MECKLENBURG COUNTY
Park and Recreation Department

MEMORANDUM

DATE: November 3, 2020

RE: Rezoning Petition #2020-137 – Clark Village

DATE: 08/11/20	MPIC: WILL
DRAWN BY: DSB	CHECKED BY: WILL
PROJECT NUMBER: 00777.00	
SCALE: 1" = 60'	
TITLE: CONCEPTUAL SITE PLAN

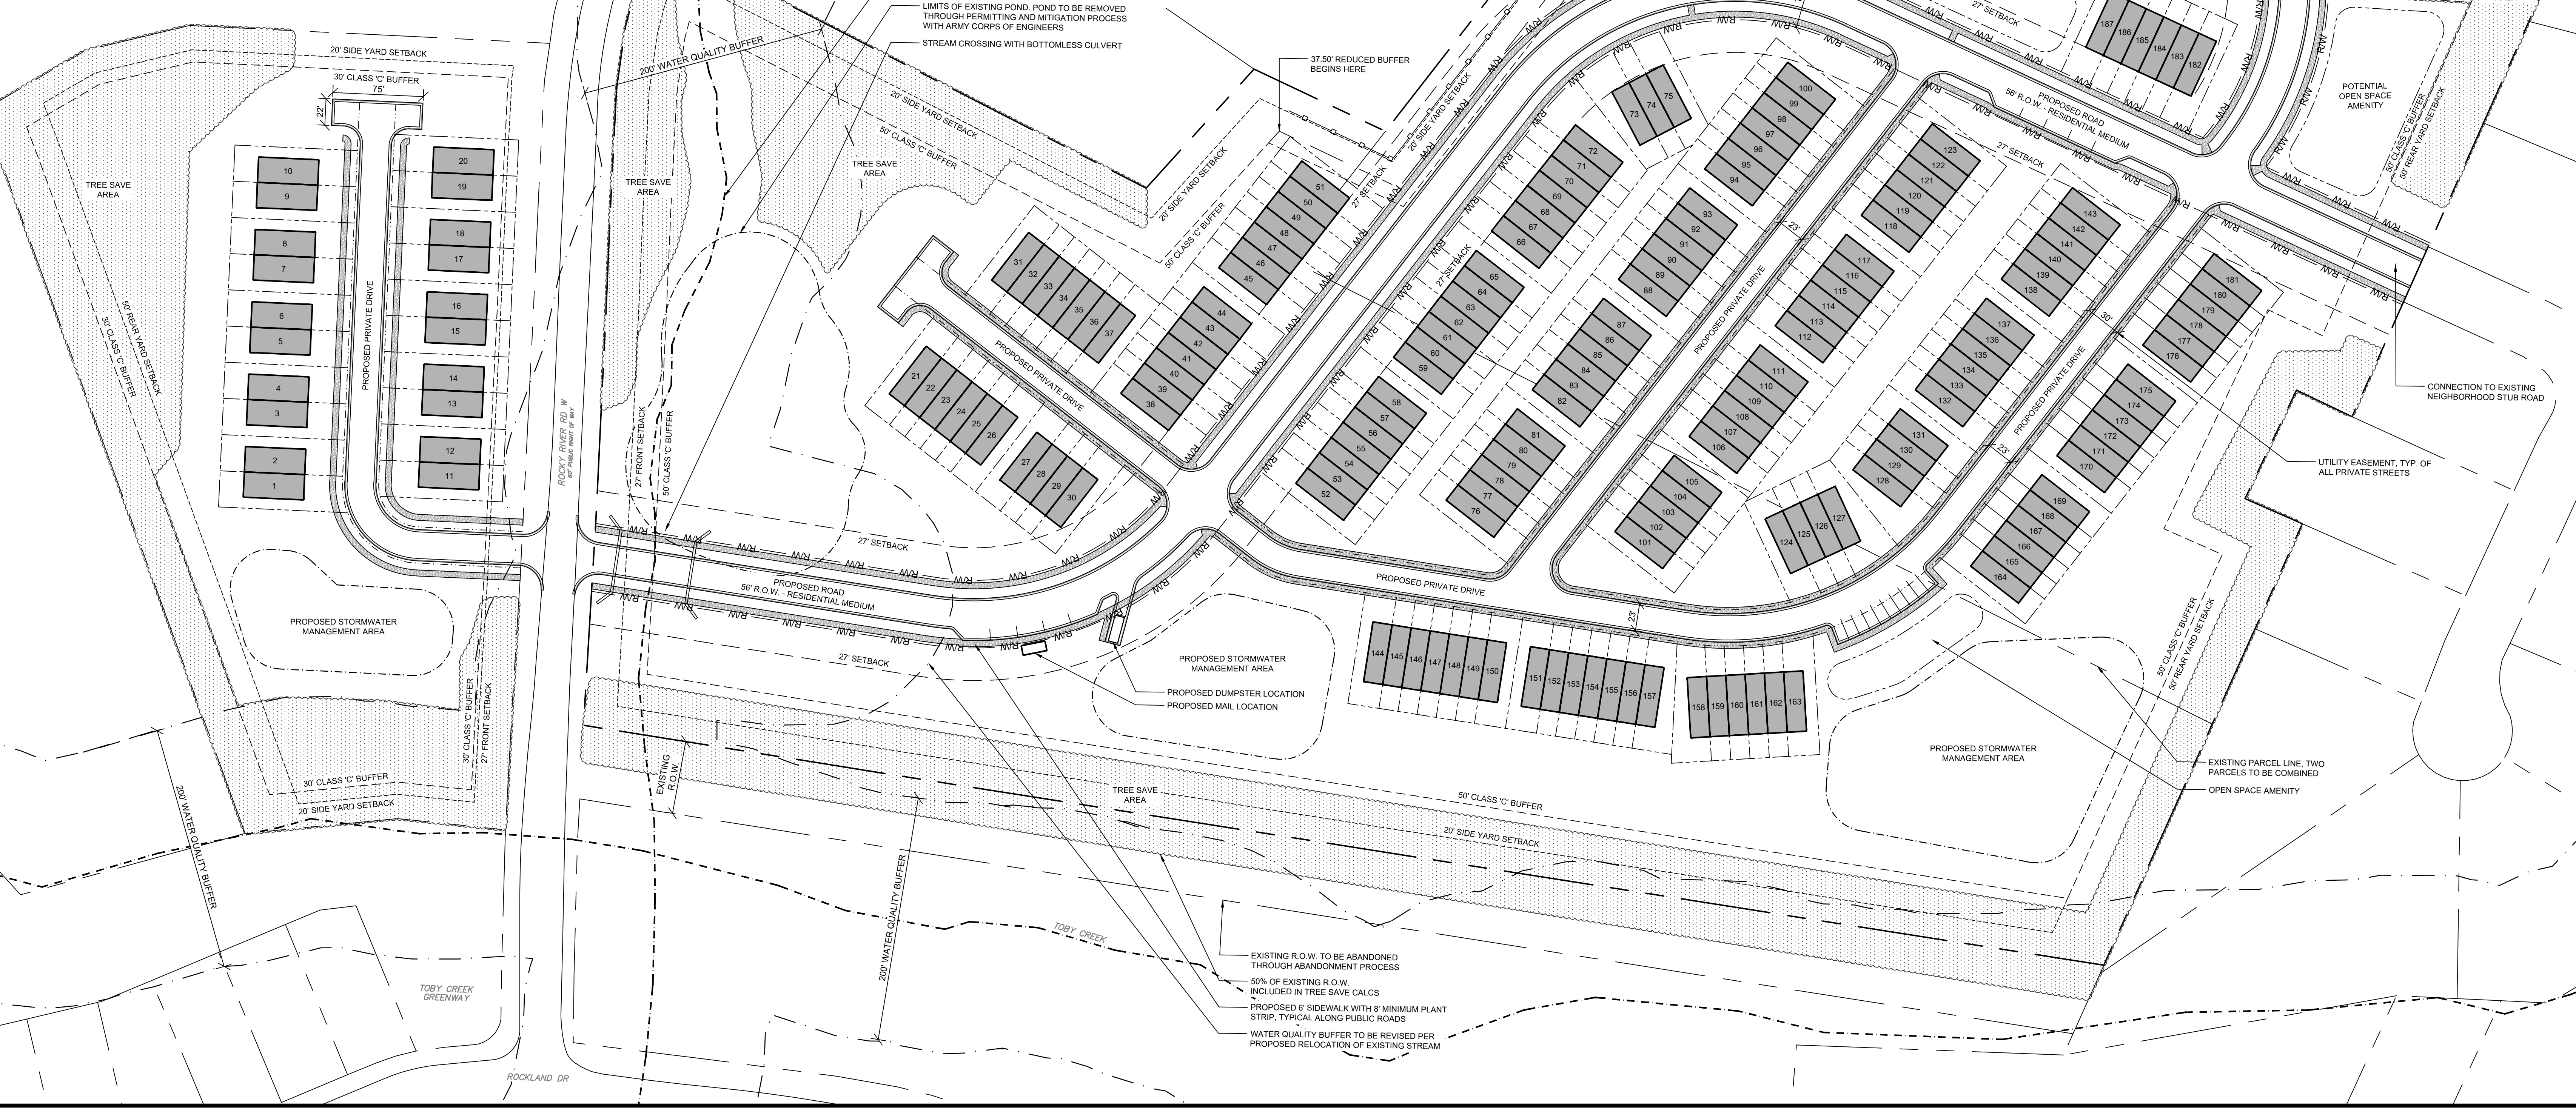
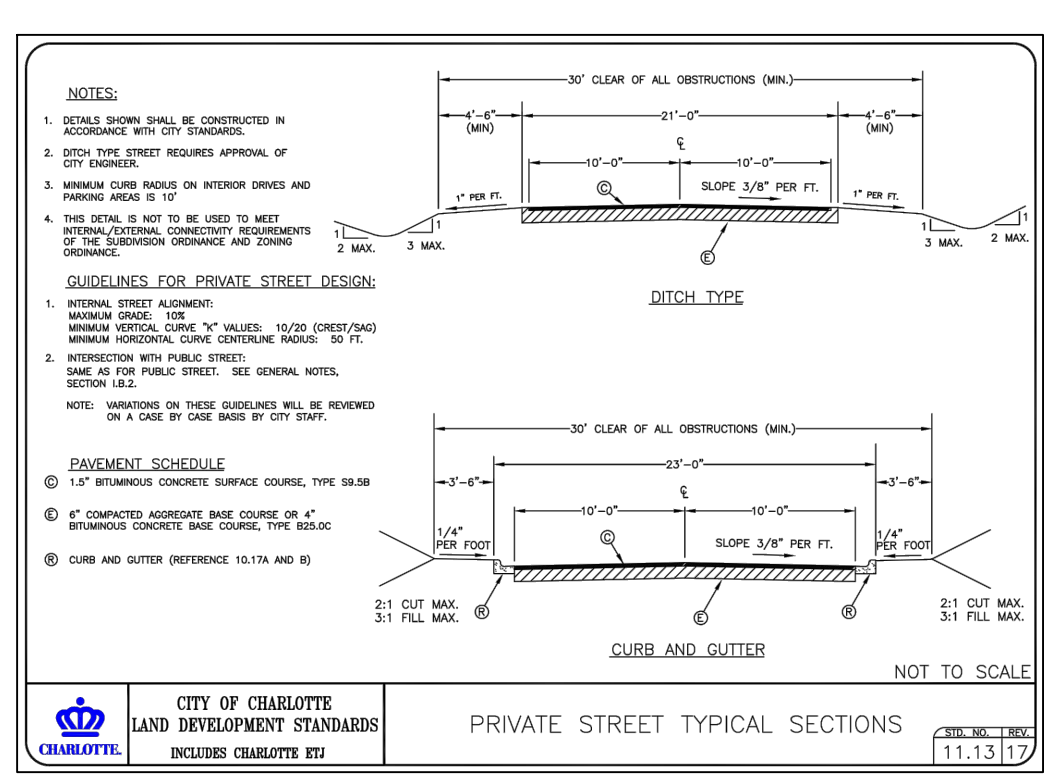
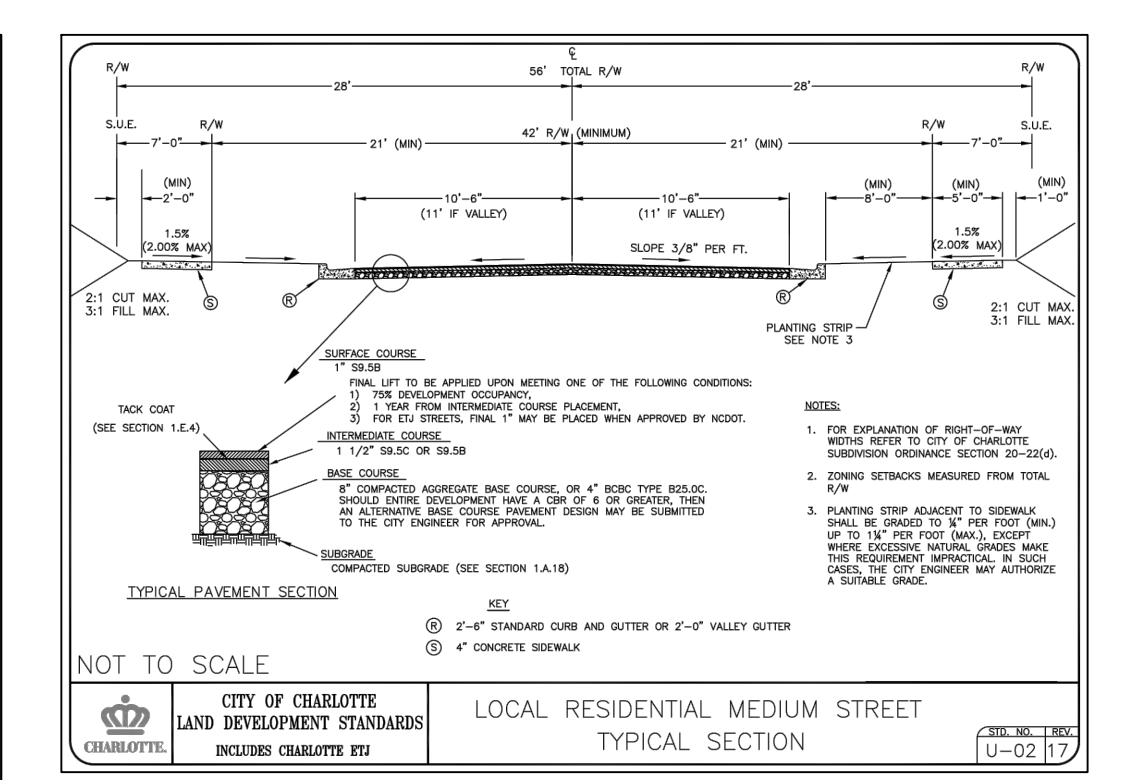
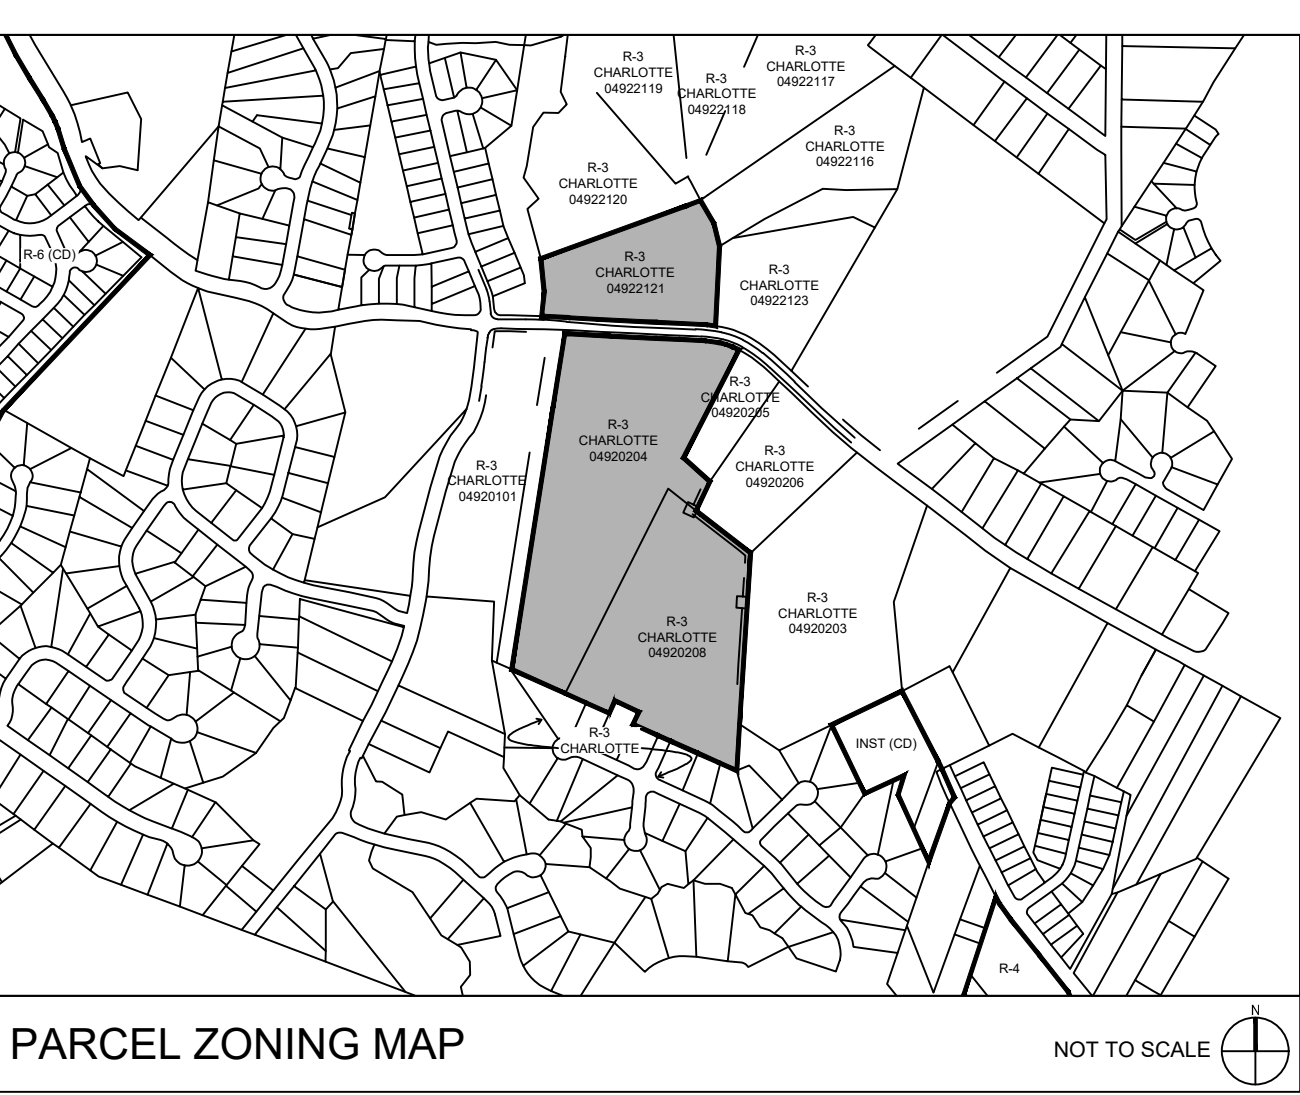
MCPR requests the petitioner consider dedicating and conveying to Mecklenburg County a minimum of 2.0 acres for a public neighborhood park. This petition is in a gap area for public open space. We would be happy to discuss in further detail upon request.
